# CITY OF ELLENSBURG

August 11, 2006

Re: Vista View

SEATTLE AVE

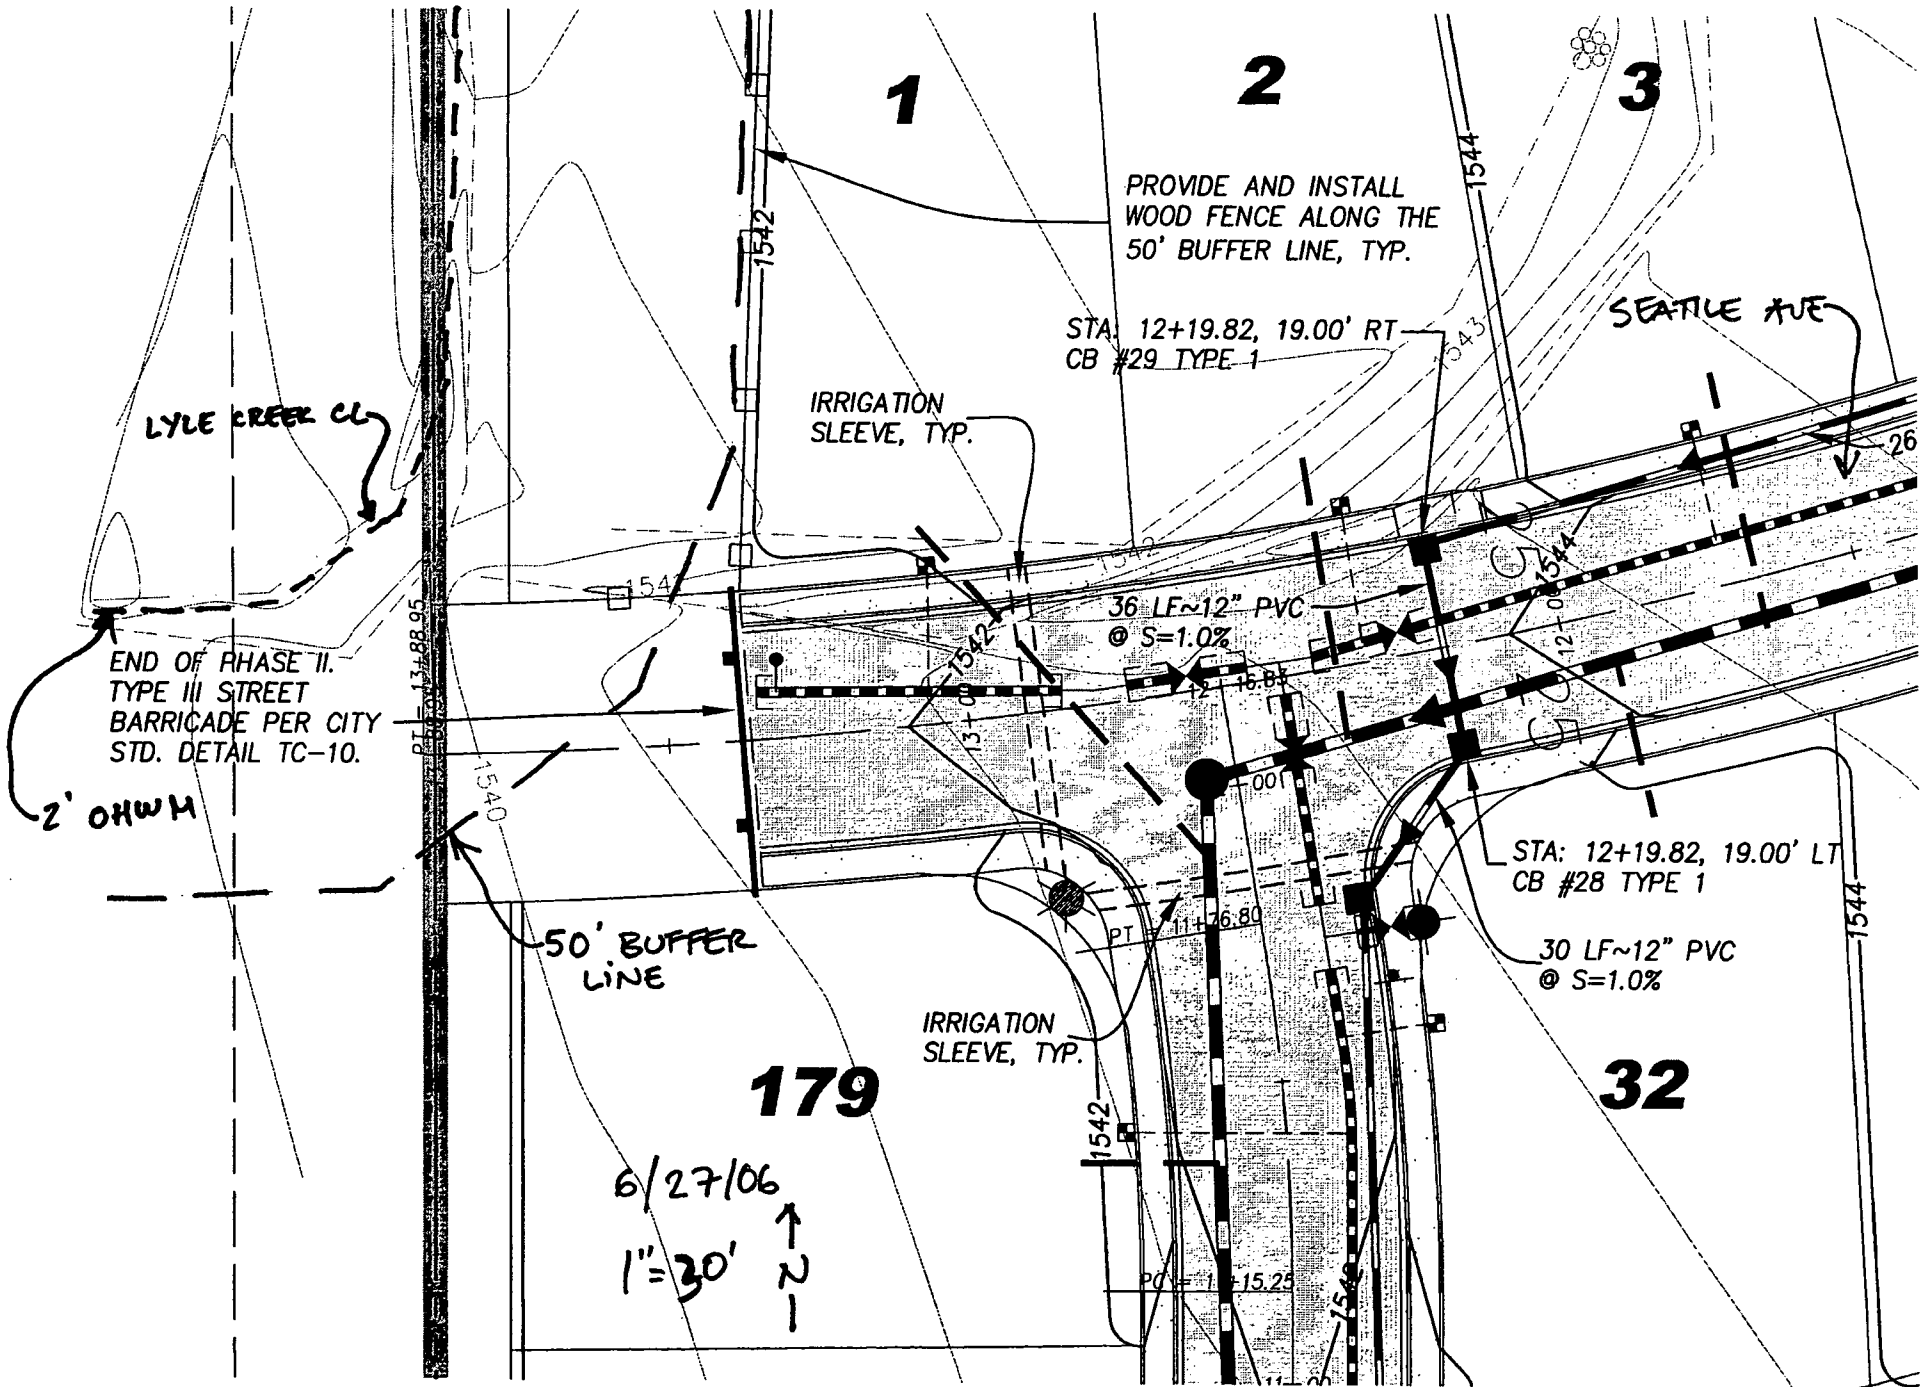
I have not heard from you regarding the buffer area at the west end of Seattle Street which is located in the new Vista View Plat being constructed by MDJ Development. The plans show that the road improvements stop 50' short of the end of the plat boundary.

My letter in June was to let you know that the City of Ellensburg requires that roads be completed along the frontage of all parcels being developed. Meaning that unless the road is completed to the full extent of the roadway on the north side of Lot # 179 the lot will not be developable.
